Appeal Decision

Appeal Ref: APP/R4408/D/17/3170443

18 Roper Lane, Thurgoland, Sheffield, S35 7AA

Plan No: SH6027

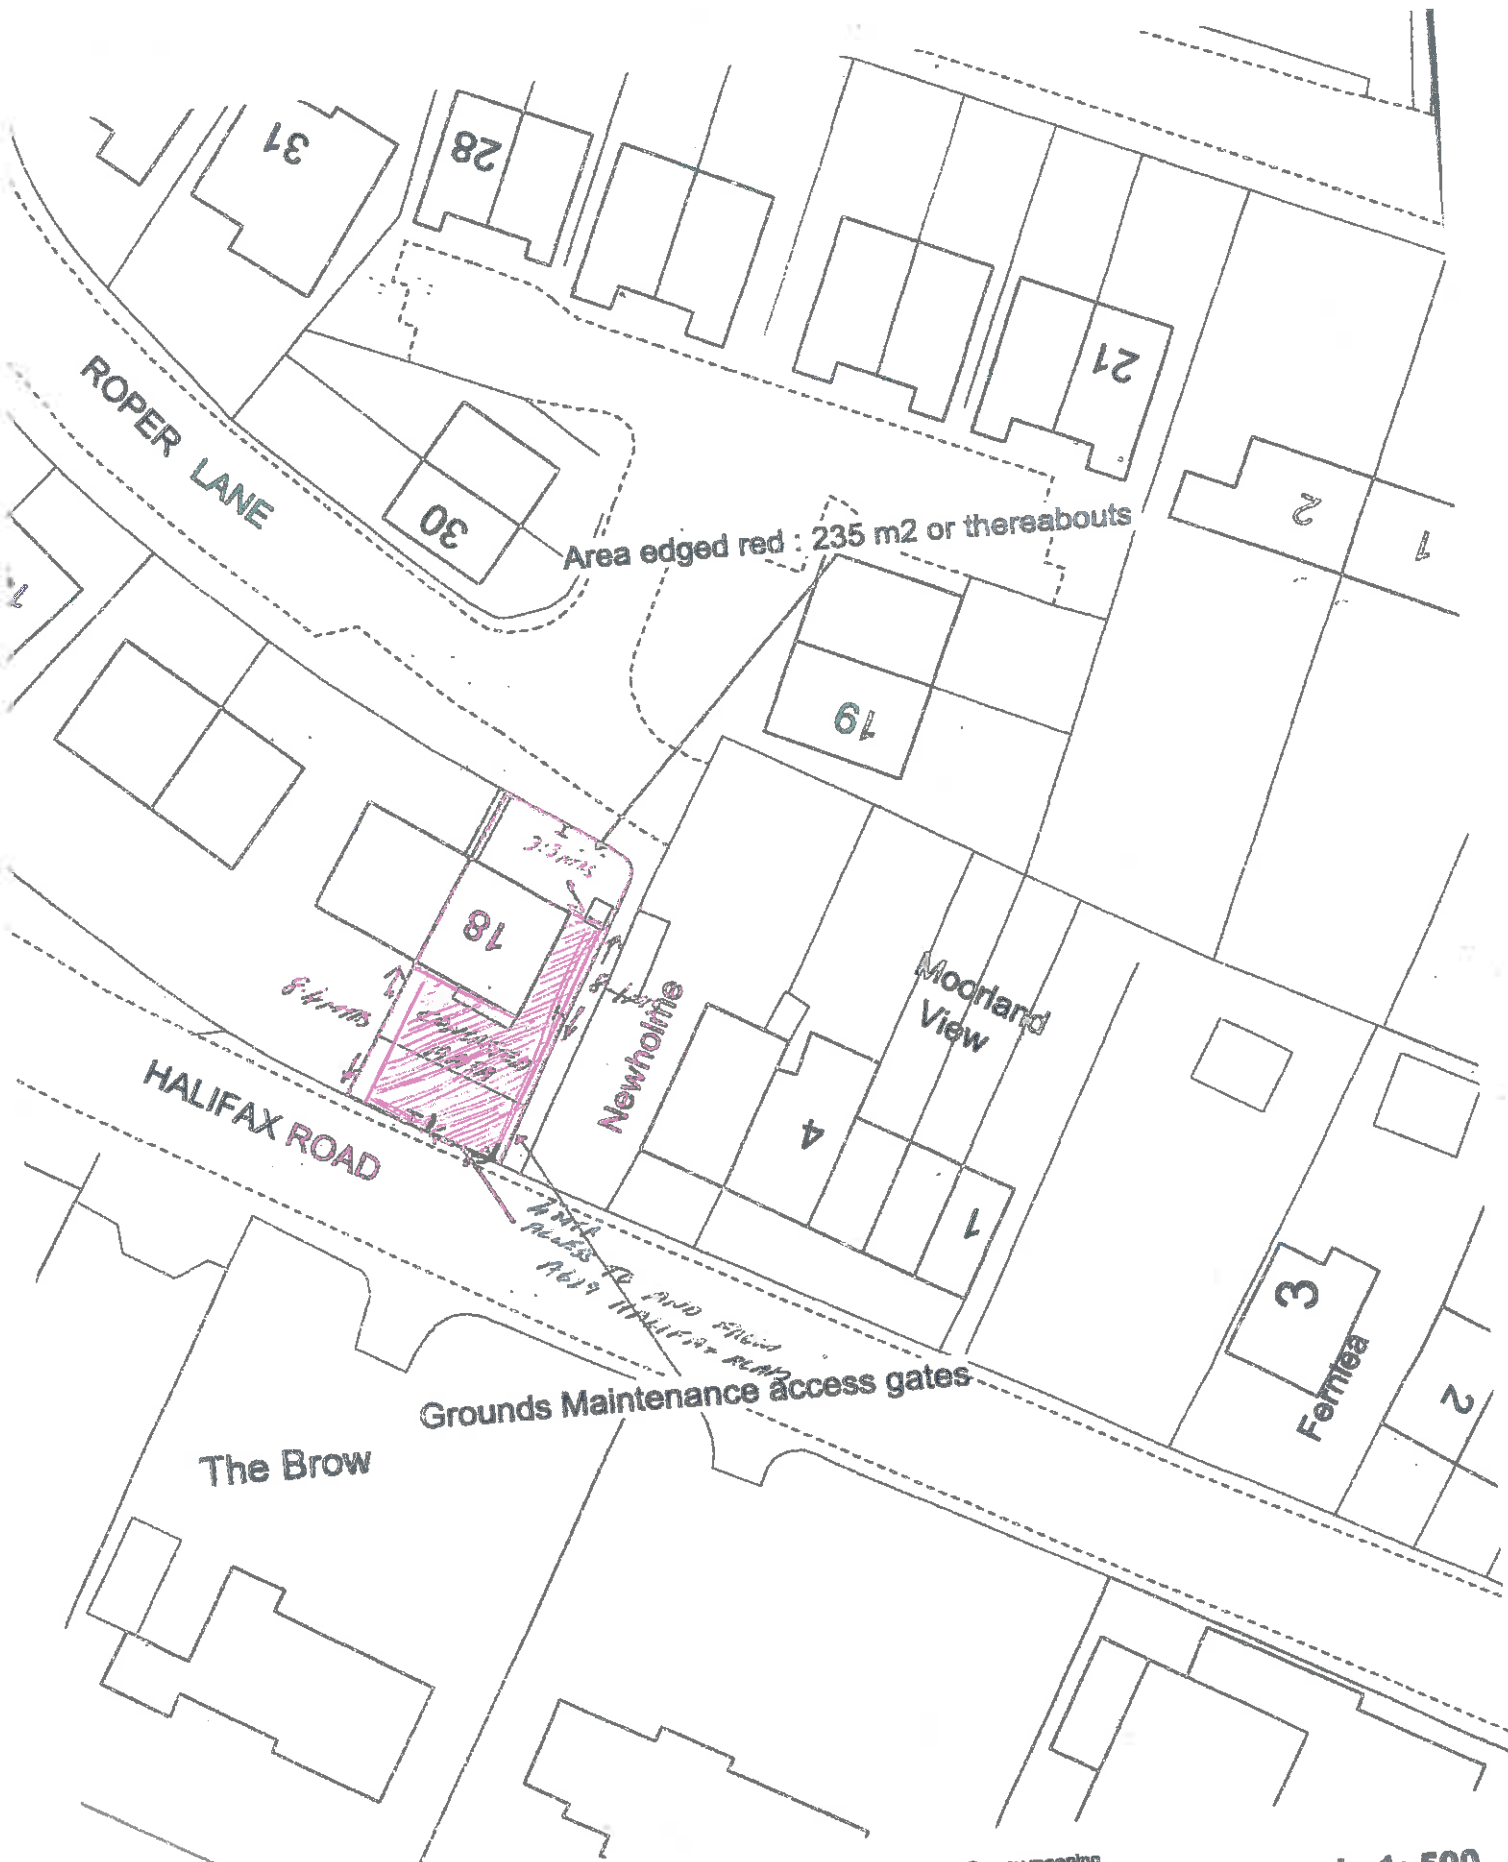
3. No. 18 is a semi-detached bungalow, the southwestern elevation of which is set back from the northeastern side of the A629 Halifax Road beyond a low walled grassed garden. The proposal includes the use of that garden area and an area to the side of the bungalow as a car parking and turning area, accessed from Halifax Road through a new opening formed in the roadside boundary wall.

5. However, a short distance to the west of the property, the A629 bends sharply to the north. As a result, the intervisibility between a driver emerging from the site and others approaching along the A629 from the north would be limited. I have had regard to the view of the appellant that the proposed arrangement would be no worse than that at the driveway of Newholme, which is the neighbouring property to the east of No. 18. However, the proposal would
-

increase the frequency and thereby the likelihood of drivers joining the highway as others round the bend a short distance to the west. Furthermore, the proposed driveway opening would be closer to the bend than that of Newholme, reducing the reaction time available to allow approaching drivers to take action to avoid a collision. I consider that the proposal would significantly increase the risk of accidents hereabouts.
